Director, Major Projects Assessment  
Department of Planning and Environment  
Application number SSI 6307  
GPO Box 39  
Sydney NSW 2001

**SUBMISSION – EIS –WESTCONNEX M4 EIS (SSI 6307)**

I make this submission to comment on the Environmental Impact Statement of Westconnex M4 East Application Number SSI6307. I object to the Westconnex M4 East motorway proposal.

8.26 TB - DENOTES DESIGN TOP OF BARRIER

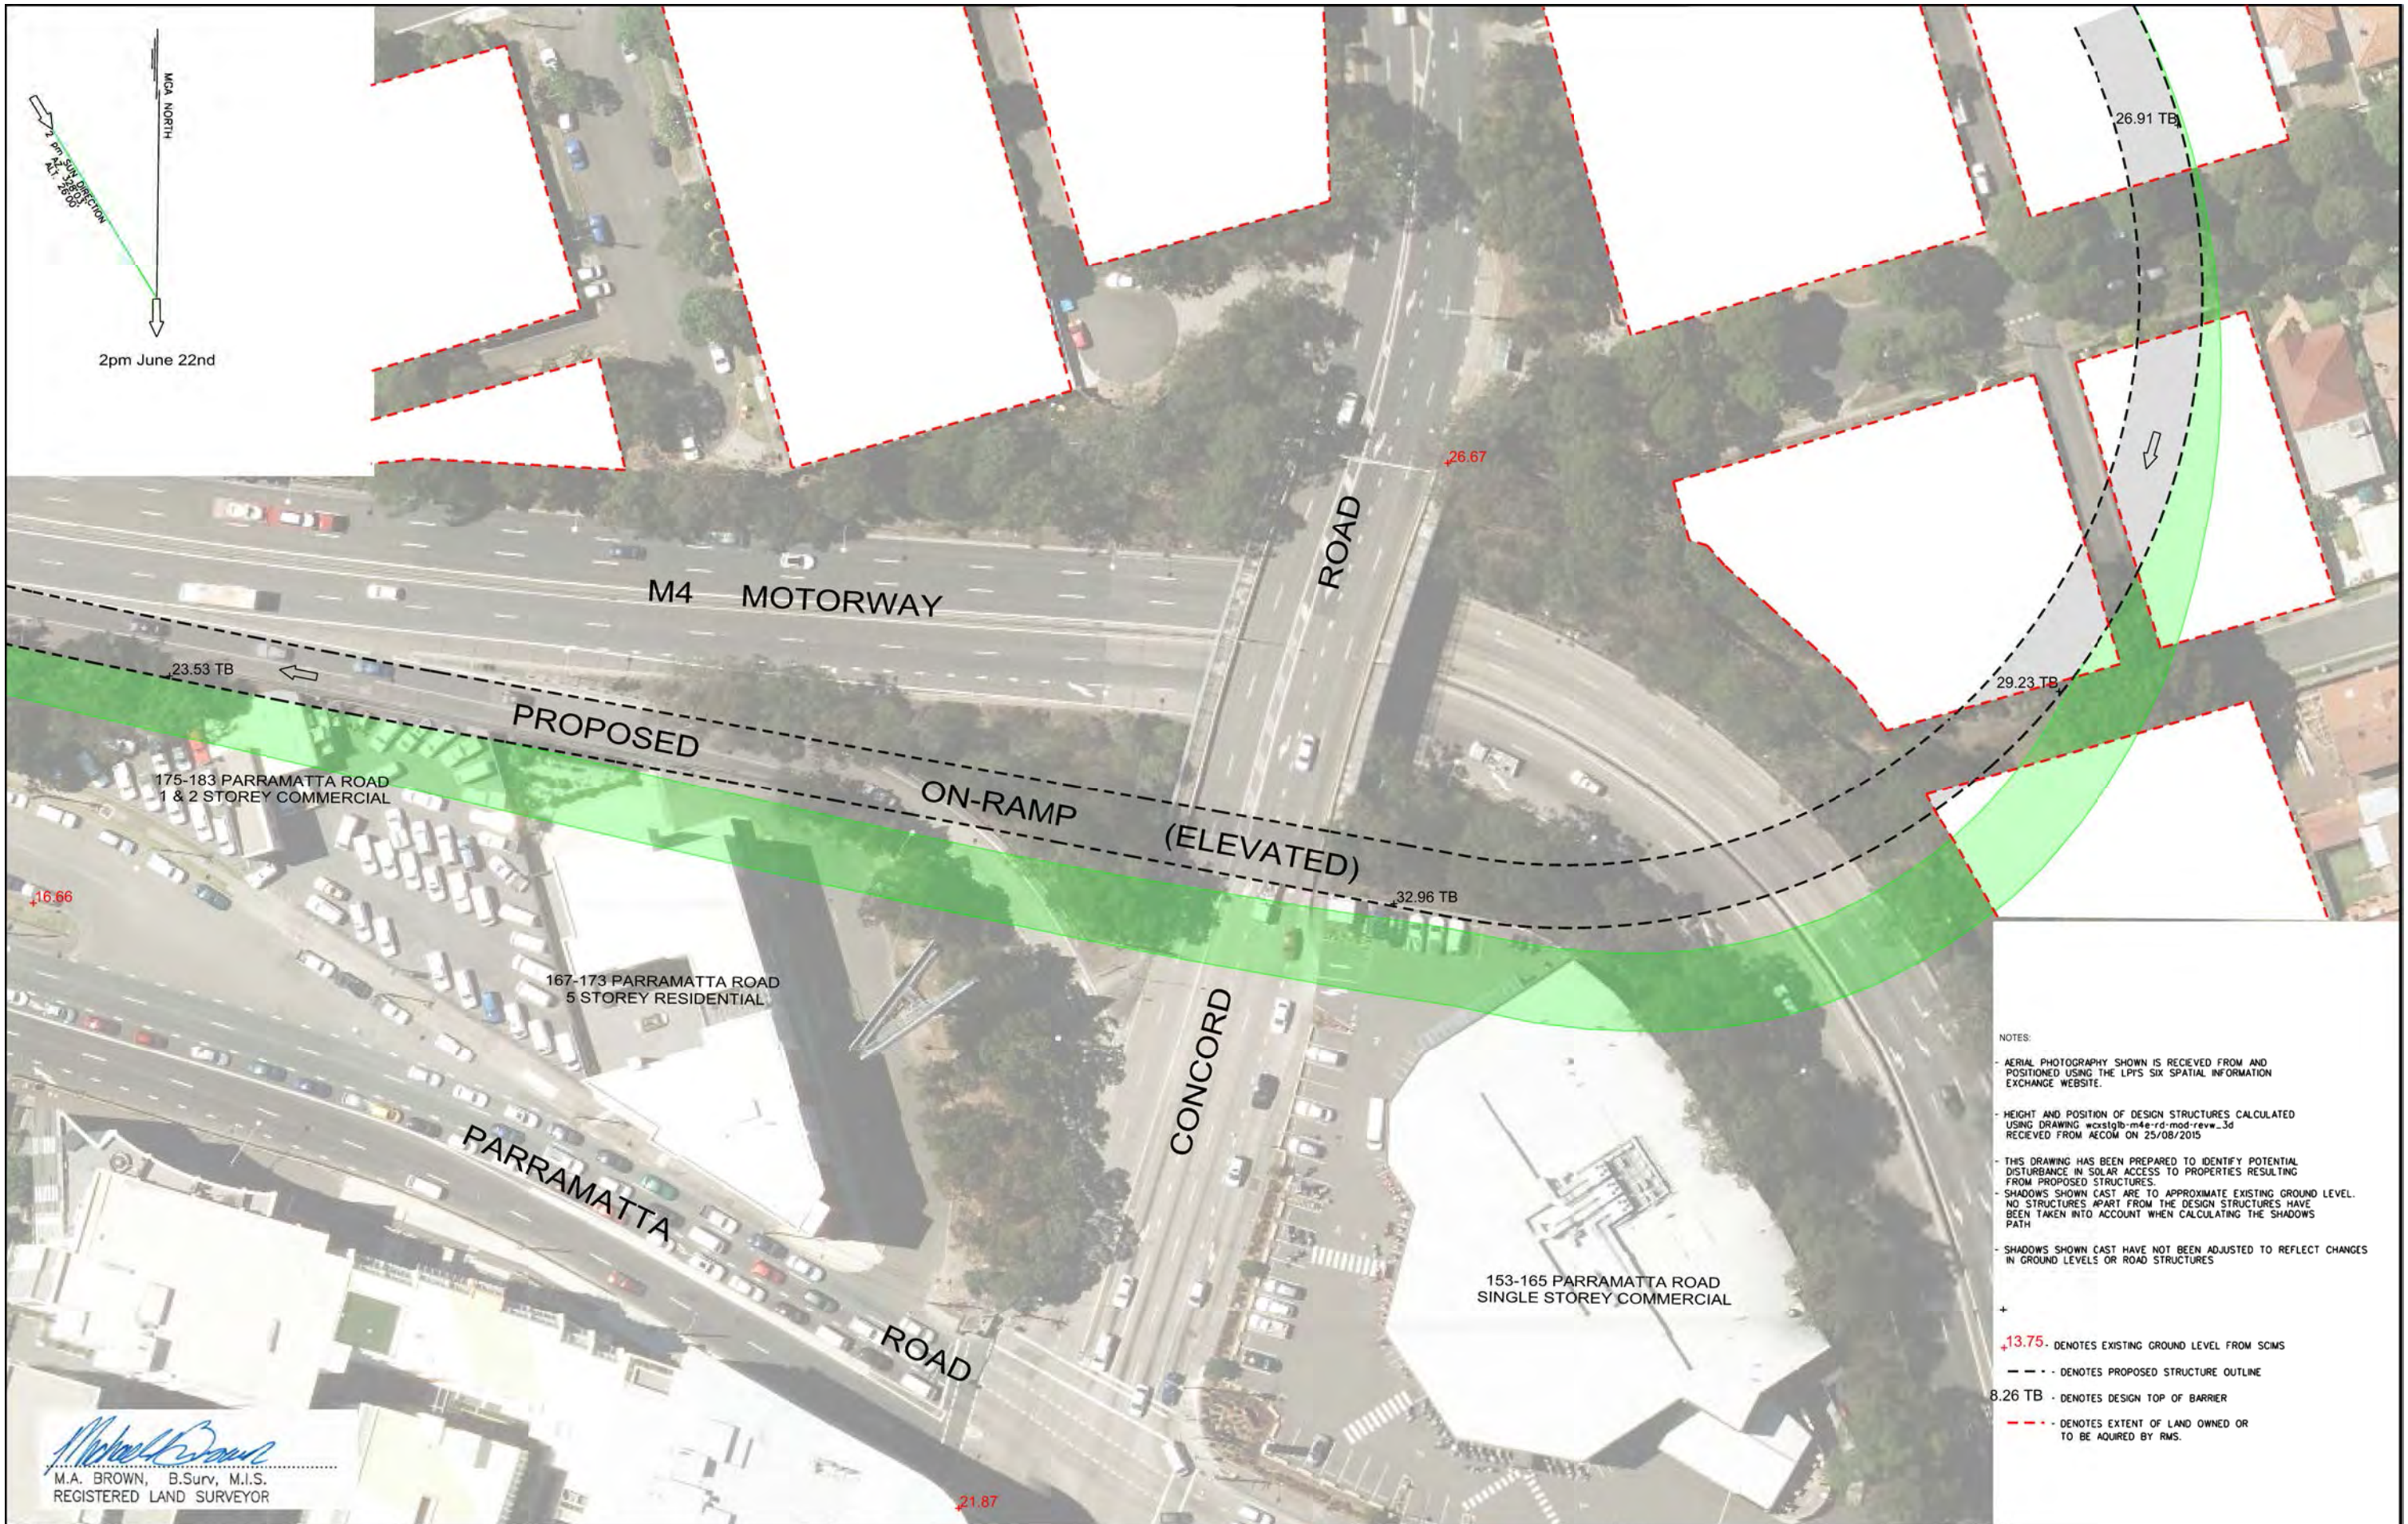
EIS App. I Clause 14.20 states that “Noise barriers have been considered in this assessment, however, based on further feasible and reasonable considerations the barrier may potentially sterilise future use of the adjacent land by restricting visibility and/or access. Therefore, consideration of at-property treatments for the triggered receivers instead of a barrier have been recommended and are to be further considered during detailed design.” The omission of noise barriers will result in a significant increase in noise on terraces and balconies in 98 Chandos Street

The EIS identifies twenty-one (21) buildings, between Orpington Street and Bland Street, as receivers that should be considered for additional noise mitigation. Sixteen (16) of these buildings trigger both of the cumulative limit and the noise increase criteria identified in the EIS. Many of the said buildings, including 77-79 and 98 Chandos Street and 1, 1A, 3-5, 7-9, 11, 13, 15 and 17 Loftus Street are high density residential constructions. A large number of residents would benefit from a noise wall, which would provide significant attenuation of noise for at least the first two floors. A noise wall should be constructed along the westbound side of Parramatta Road, running from Orpington Street to Bland Street. At the Chandos Street intersection, a noise wall should be provided on the east side of the street in order to provide noise mitigation for 77-79 Chandos Street and should be provided along the southern side of part of the proposed driveway at 98 Chandos Street in order to provide noise mitigation for 90 Chandos Street.

1. A noise wall should be constructed along the westbound side of Parramatta Road, running from Orpington Street to Bland Street. At the Chandos Street intersection, a noise wall should be provided on the east side of the street in order to provide noise mitigation for 77-79 Chandos Street and should be provided along the southern side of part of the proposed driveway at 98 Chandos Street in order to provide noise mitigation for 90 Chandos Street.
2. The criteria for the provision of architectural noise mitigation should be the same for all residences and all floors. The EIS is deficient in that it has completely excluded the floors above the second floor in its modelling and recommendations, except to state that RMS has a policy of completely excluding even the consideration of noise mitigation above the second floor.
